Application No: EP/53/22/HH
Site Address: 38 Hillview Crescent East Preston BN16 1RQ
Description of works: Hip to gable loft conversion with rear dormer.

Thank you for your internet representation made on 14th June 2022 which has been recorded as an objection with the comments as follows:

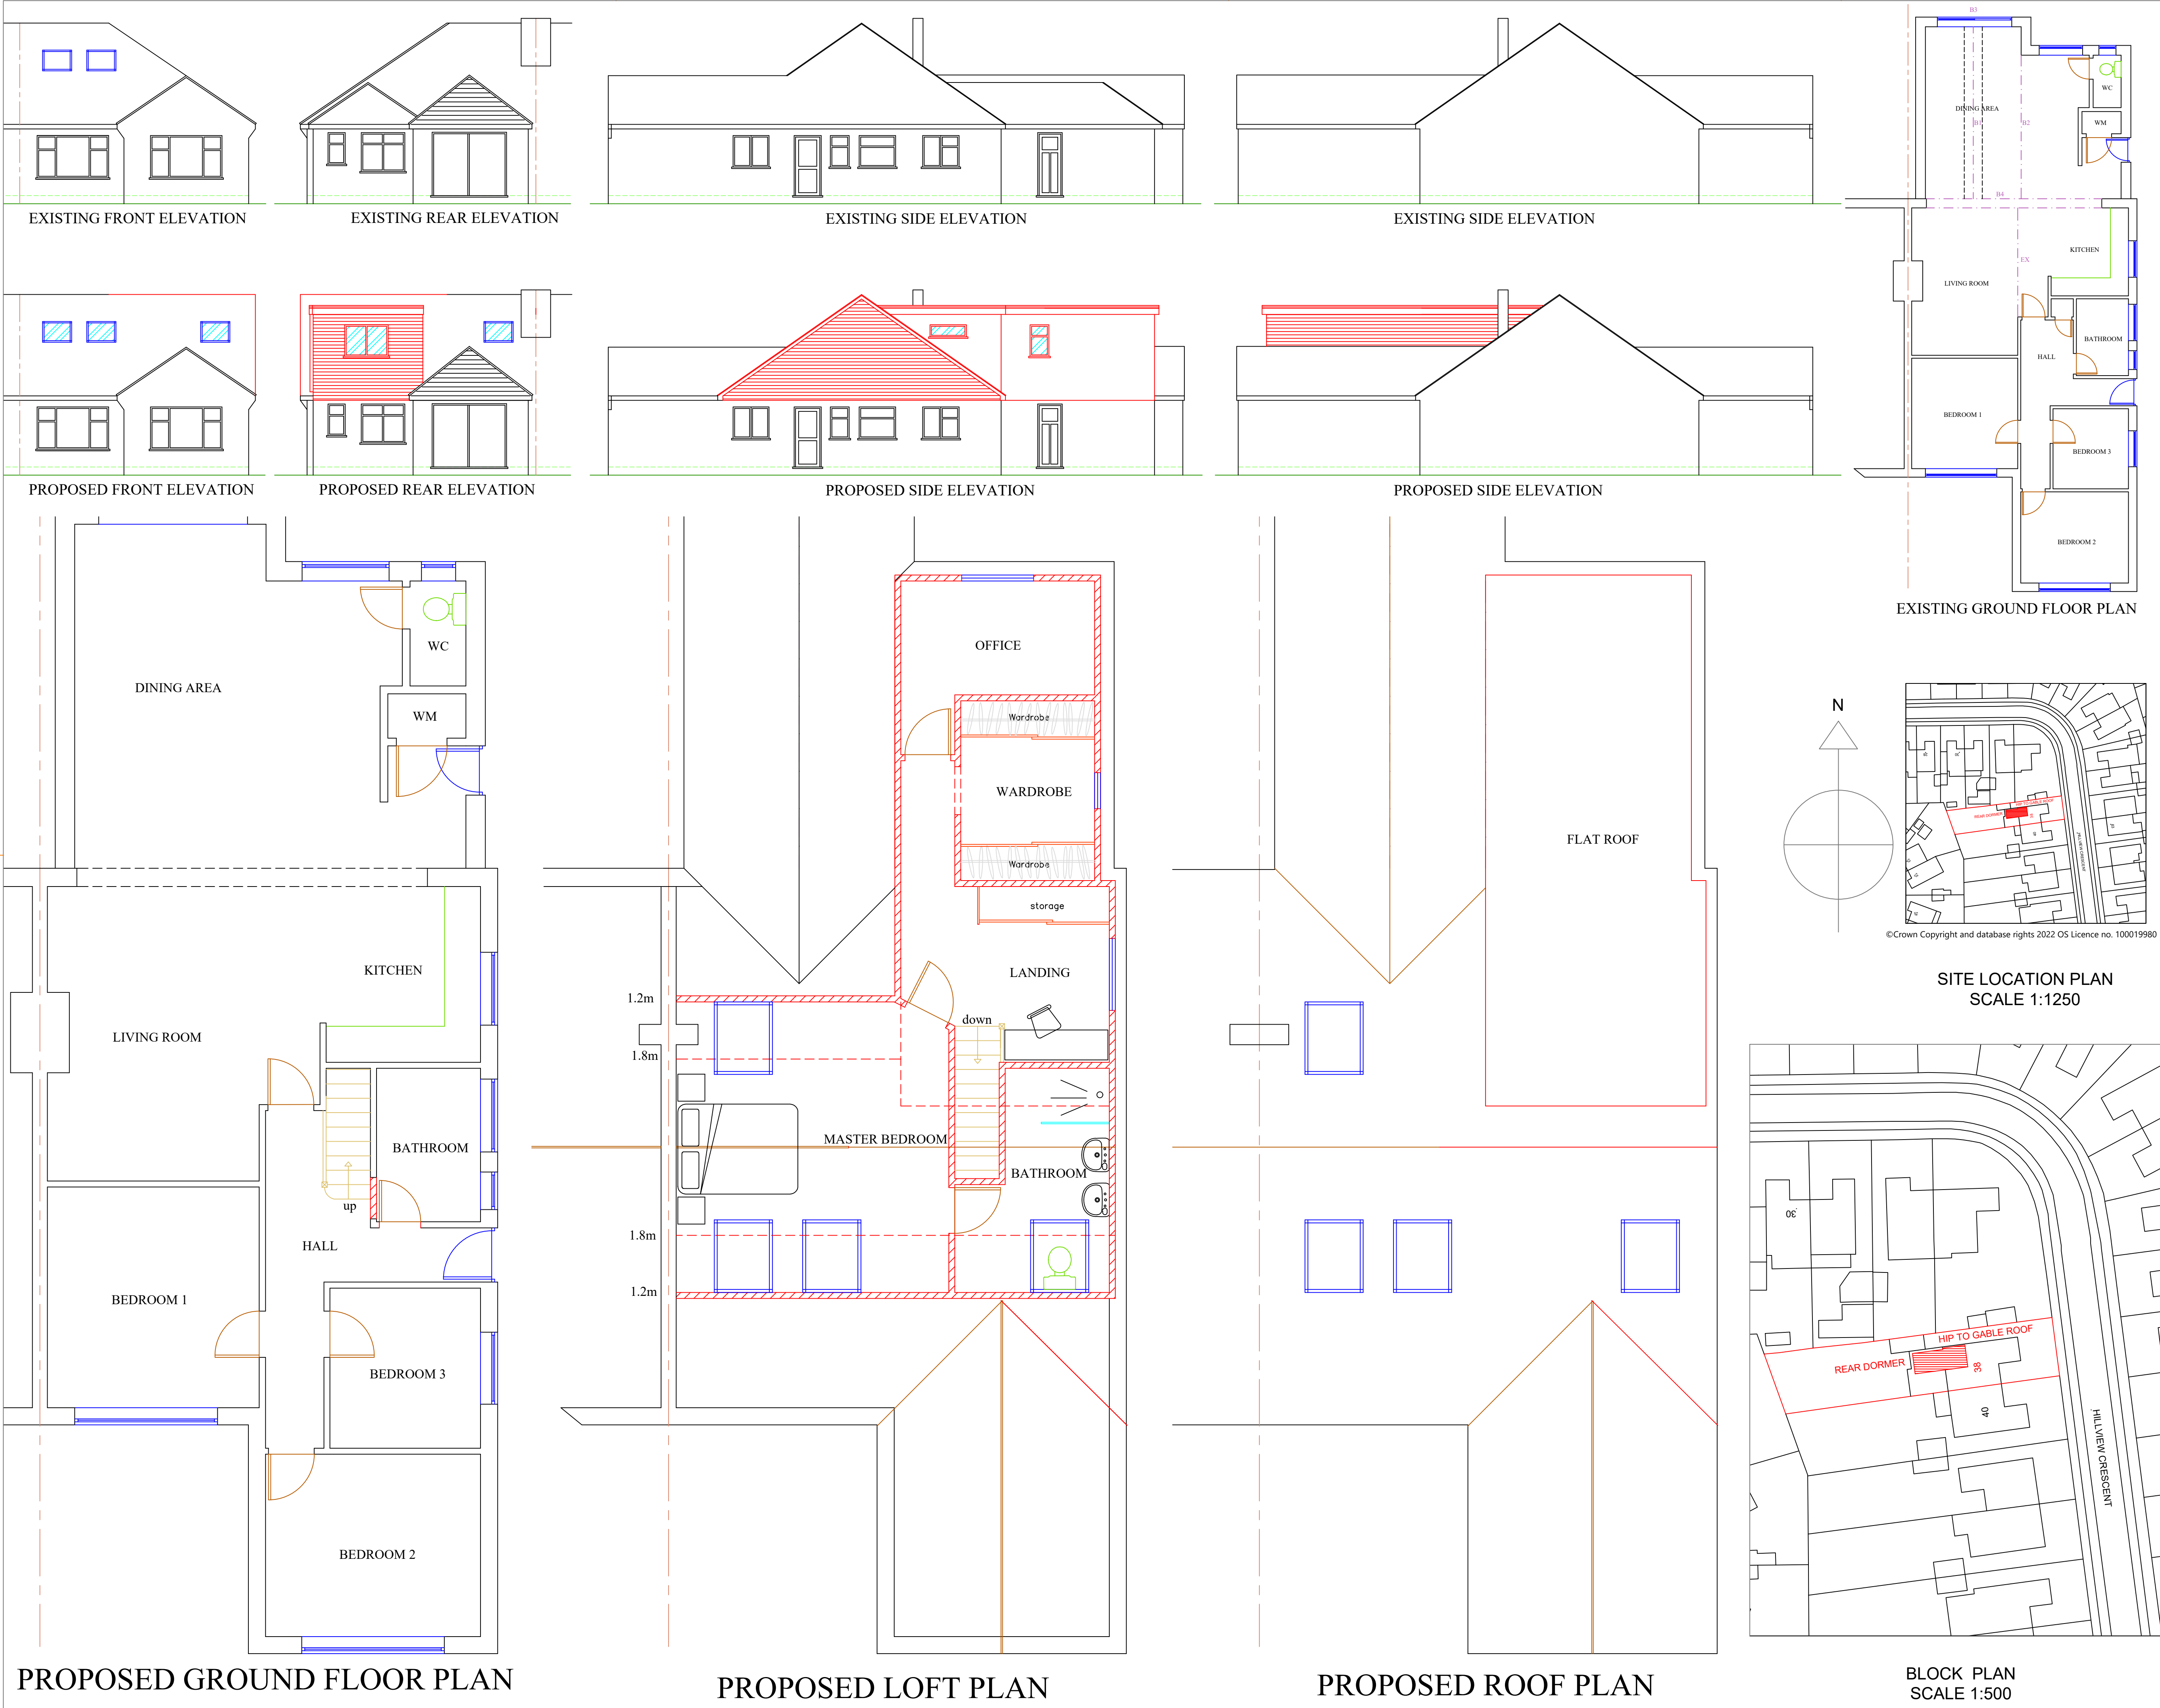
Our bungalow is on the north side of 38 Hillview Crescent and so our view, in our small back garden, on looking at the plans will be of the vast expanse of the brick or cladding used in the very long rear dormer.

4:16 The enlarged house should not be unbalanced in appearance or so large as to be out of scale with the other houses in the road.

Hillview Crescent is included in Policy 3 Character Area Two and this states, where new rooms are to be created in a roof space, ensure the height of the roof is increased and the basic form of the roof is not altered.

4:27 The main characteristic of this area is the predominance of bungalows. The priority for the policy is to resist increases in height. New building should be no higher than the existing buildings a road. If a bungalow is enlarged by constructing in the roof space, the height of the roof should not be increased and the basic form of the roof should not be changed. A hipped roof should only be changed to a gable at the rear.

If the plans for the extension were revised to a gable end with a rear dormer within the roof space of the original bungalow, similar to dormers having been made to other bungalows in this street, then we would not object.
